Modification of Approval

Restoration and refurbishment of the Sirius Site (SSD_10384_Mod 3)

2-60 Cumberland Street, the Rocks

August 29, 2022

3 GA - NORTH ELEVATION_CUMBERLAND
1 : 200

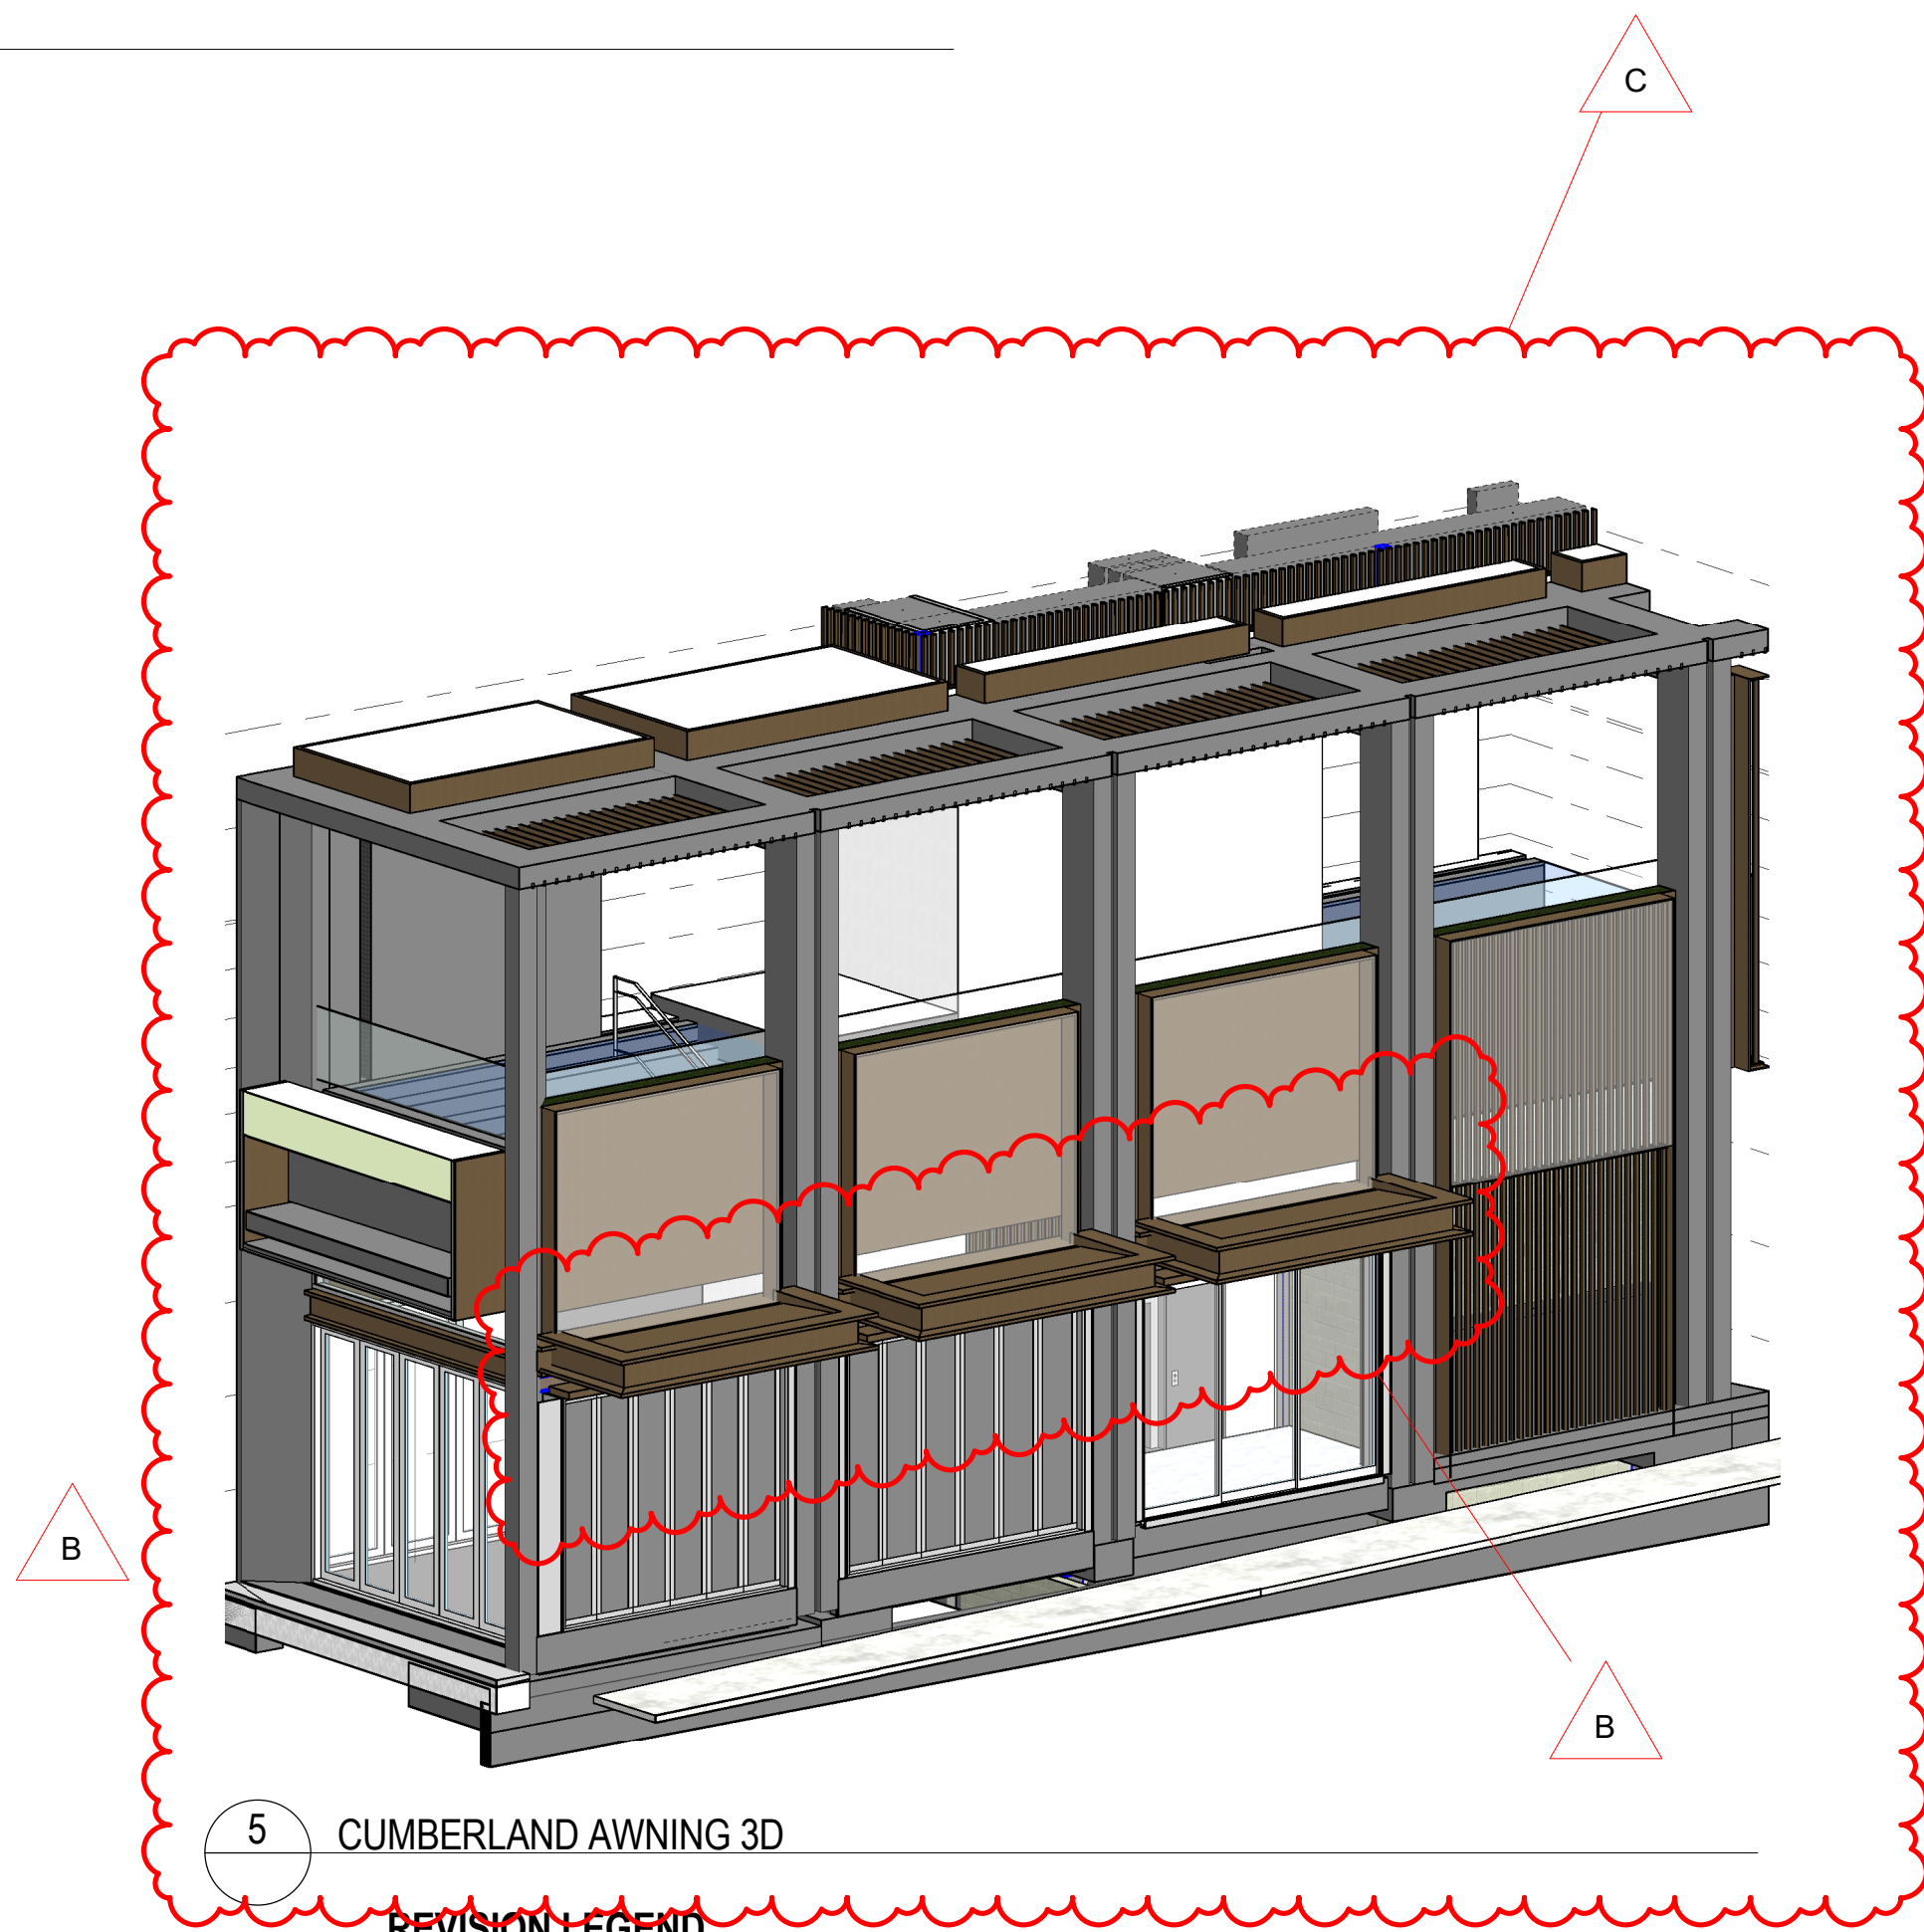
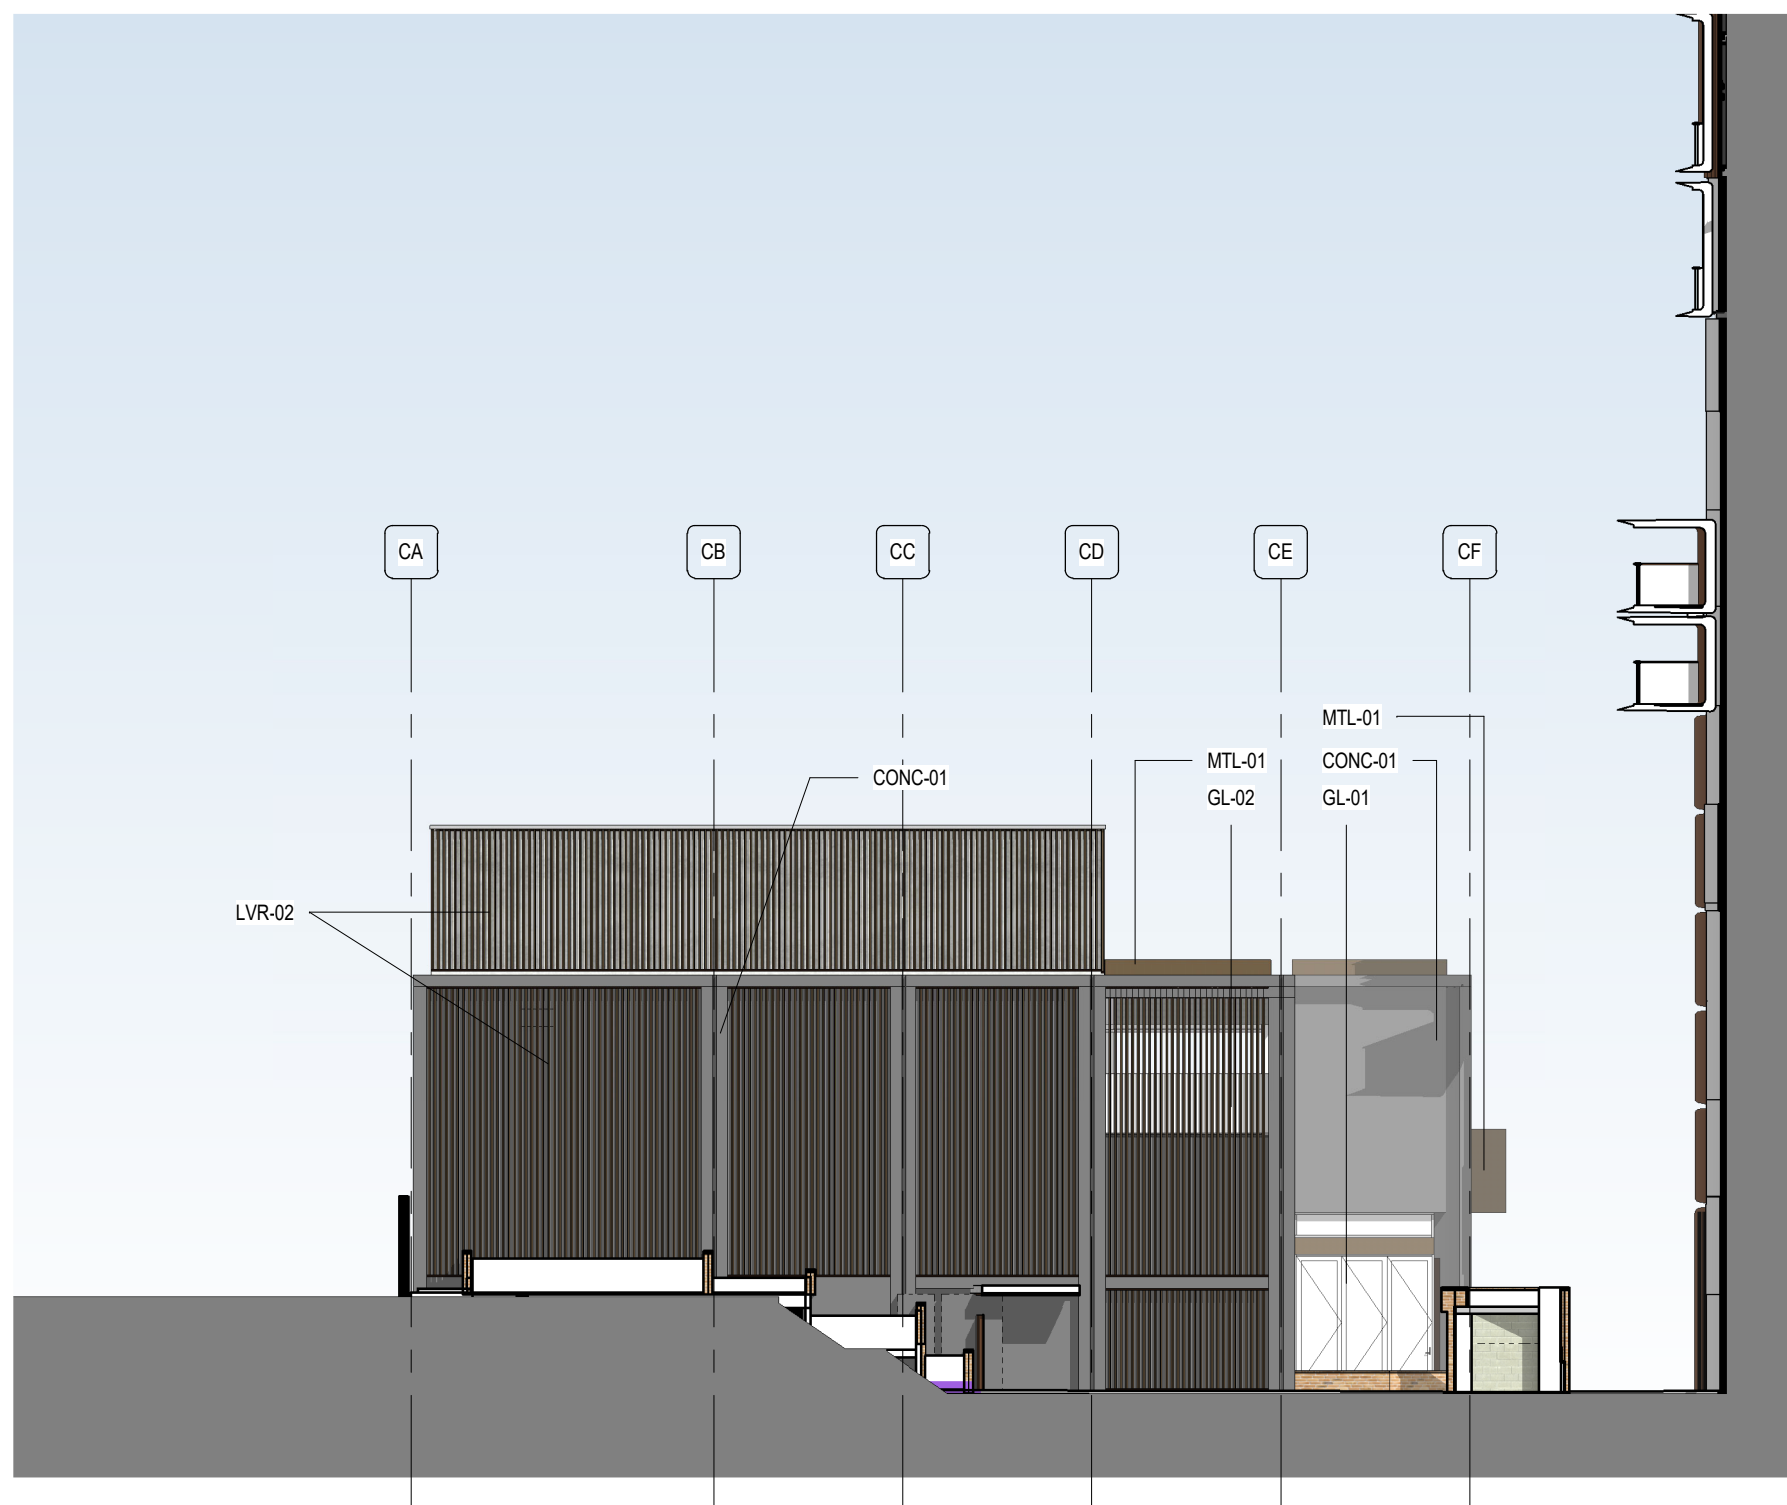
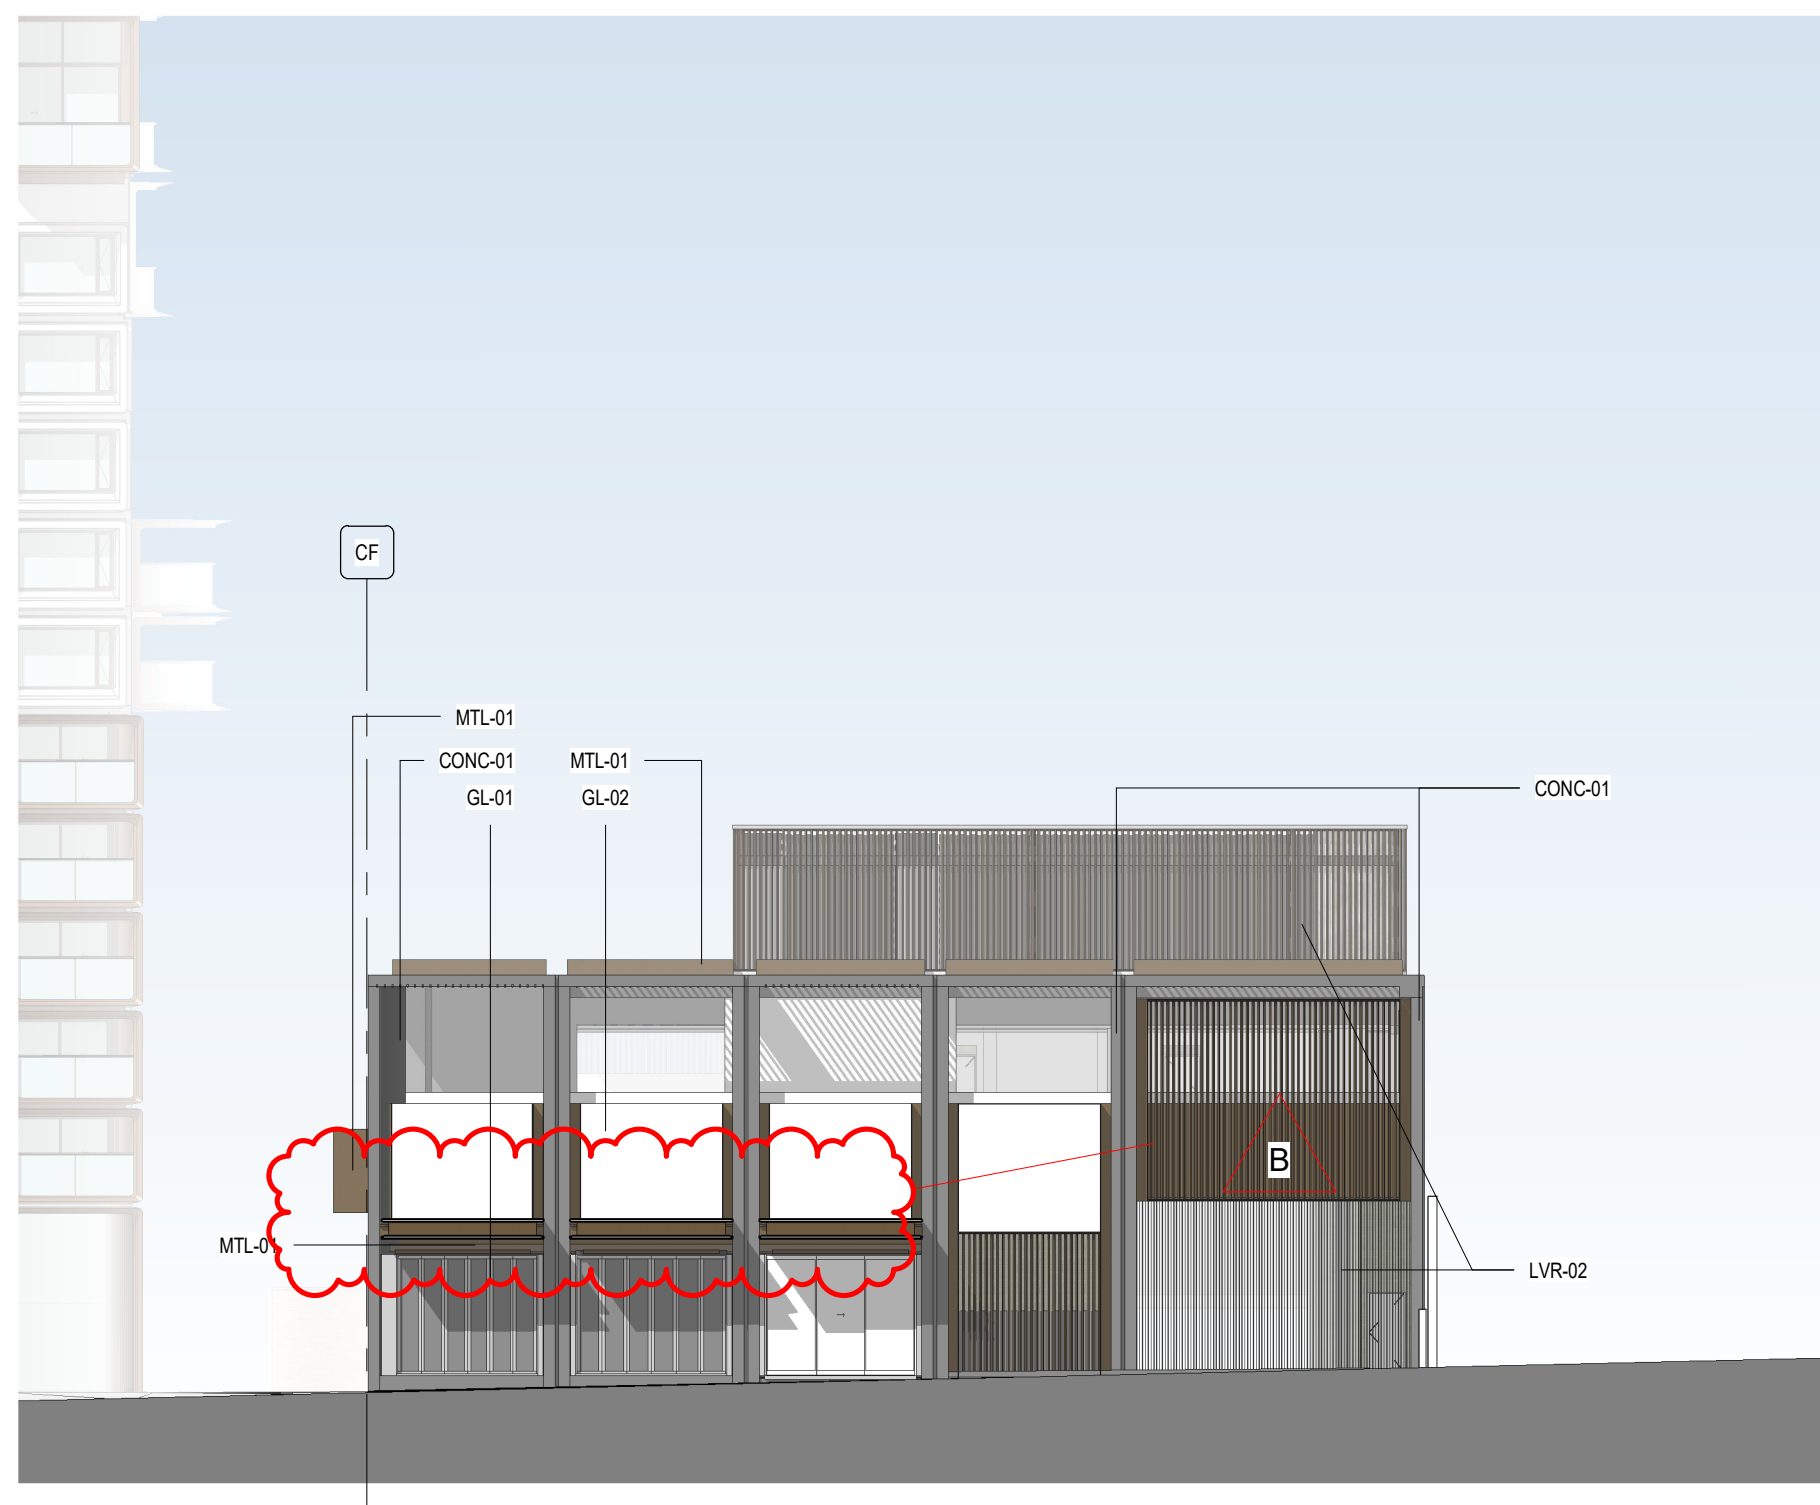
This modification proposes to make the following changes to the awning fronting Cumberland Street:

- Reduce the width from 3m which extended to the face of the kerb to 1.78m to avoid any conflicts with vehicles on Cumberland Street and for greater consistency with the Sydney DCP which requires awnings to be setback 1m from the face of the kerb
- Increase the height from 2.50m to 3.20m to ensure consistency with the Sydney DCP which requires awnings to be between 3.2m and 4.2m above the footpath.

This is shown at Figure 2 and in the plans at Appendix B. The relevant provision of the Sydney DCP are further discussed in Section 4.4.

Figure 2: North Elevation Approved (RHS) and Proposed (LHS)

The amended awning would have a height of 3.20m consistent with the DCP requirement. The proposed width of 1.78m is less than required range of 2m to 3.6m but meets the requirement to be at least 1m from the face of the kerb.
